MMO Reference: DCO/2022/00007
Planning Inspectorate Reference: EN010125
Identification Number: 20050160

Planning Act 2008, RWE Renewables UK Dogger Bank South (West) Ltd and RWE Renewables UK Dogger Bank South (East) Ltd Proposed Dogger Bank South Offshore Wind Farms Order

Deadline 4

This document comprises of the MMO's Deadline 4.

Figure: 2-4	Drawing No: PB2340-MAR-OF-ZZ-DR-Z-0015	
Co-ordinate system: WGS 1984 UTM Zone 31N	Page Size: A3	Scale: 1:950,000
Project: Dogger Bank South Offshore Wind Farms	Report: Heat Mapping Report: Atlantic Herring and Sandeel

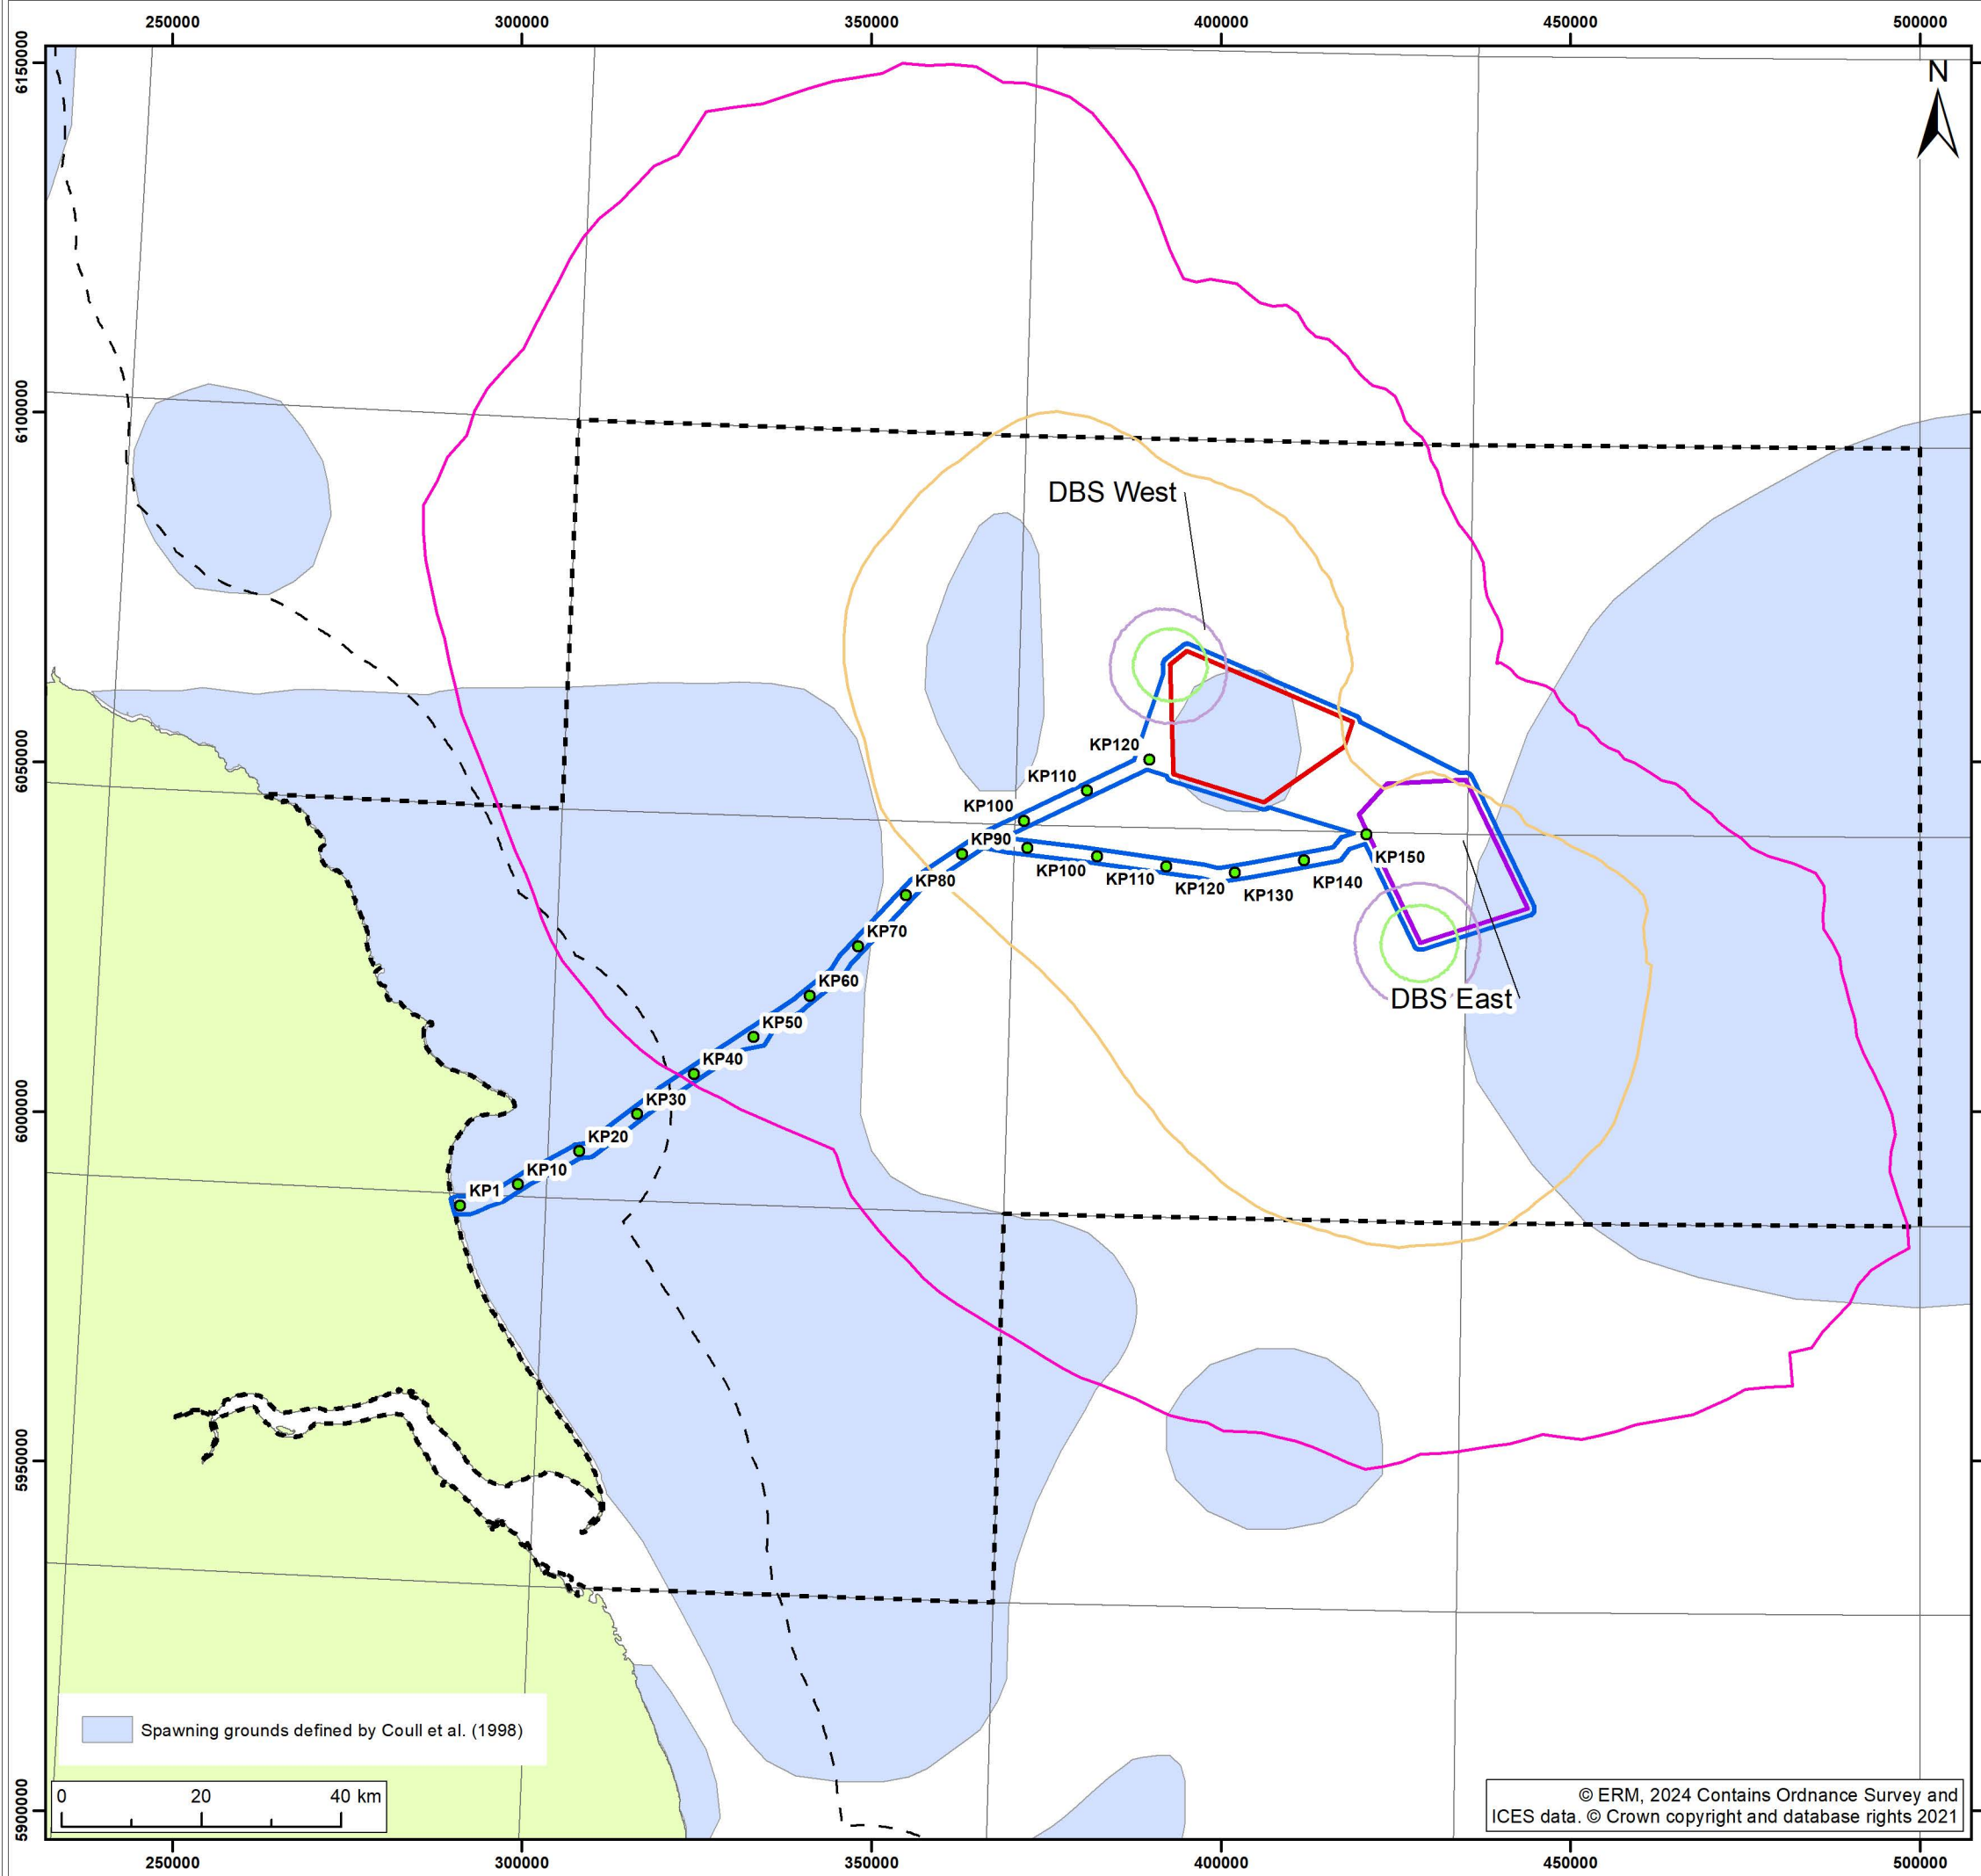
"The Applicant's would like the MMO to clarify whether the >600 larvae per metre squared (m²) category consists of anything other than high abundance that would warrant a change to the figure's legend, and if so, what the updated categories should be; bearing in mind the intention of the display of IHLS abundance data in this report as an indicator of spawning activity."

1.7.3 With regards to the Applicant's request for clarification on "whether the >600 larvae per m² category consists of anything other than high abundance", it is not entirely clear what they are asking. In brief, no, the MMO would not expect there to be a category higher than 'high abundance' (assuming the four categories in the Applicant's original plot represent very low, low, medium and high larval abundance, see Figure 1 below), however this is not what the MMO was asking for in previous advice. The MMO apologises if this was unclear. As outlined in the advice, a high abundance category of >600 larvae/m² is not appropriate when presenting larval data for a 15-year period, for the purpose the Applicant is using it for, as it is not uncommon for areas within the main spawning grounds to record thousands, or tens of thousands, of larvae per m² and so a point on the map indicating '>600 larvae/m²' could be representing a density of 601, or 6000 larvae/m², there's no way to differentiate between these values, or from which year of data these values come from. From example an area of spawning ground may have a larval abundance of 6000 larvae/m² at the beginning of the timeseries, but see larval abundances decrease overtime, however this is not reflected on the current presentation.

- 1.7.4 In order to fully examine and understand the spatial and temporal variation in herring spawning activity across the spawning ground, relative to the location of the export cable route, it is necessary to see each year of data presented individually with a consistent scale showing contours of larval abundance in m² with a figure legend representing the concentration of larvae within each band. The MMO has included an example of a similar map produced by the Applicant of the Rampion Extension (Rampion 2) OWF project as an example of what we are looking to see (Figure 2 (a-c)).

- 1.7.5 The Applicant should note that each year of data is presented as a separate plot, and that the figure legend corresponds to the varying bands of ‘heat’ with a range of larval abundances. The scale in these example figures from Rampion shows range bands of herring larval abundances which are consistent between figures. The Applicant is already in possession of 15 years of IHLB data as this has been used to provide Figure 2.7 in the original Deadline 1 heatmapping report. In providing each year of IHLB data as standalone annual ‘heat’ maps, the Applicant will demonstrate where there are areas of consistently high or low spawning activity relative to the location of the export cable route. This will support any possible refinement of the recommend restriction on cable works, alongside the other key missing evidence requested section 2.2.10
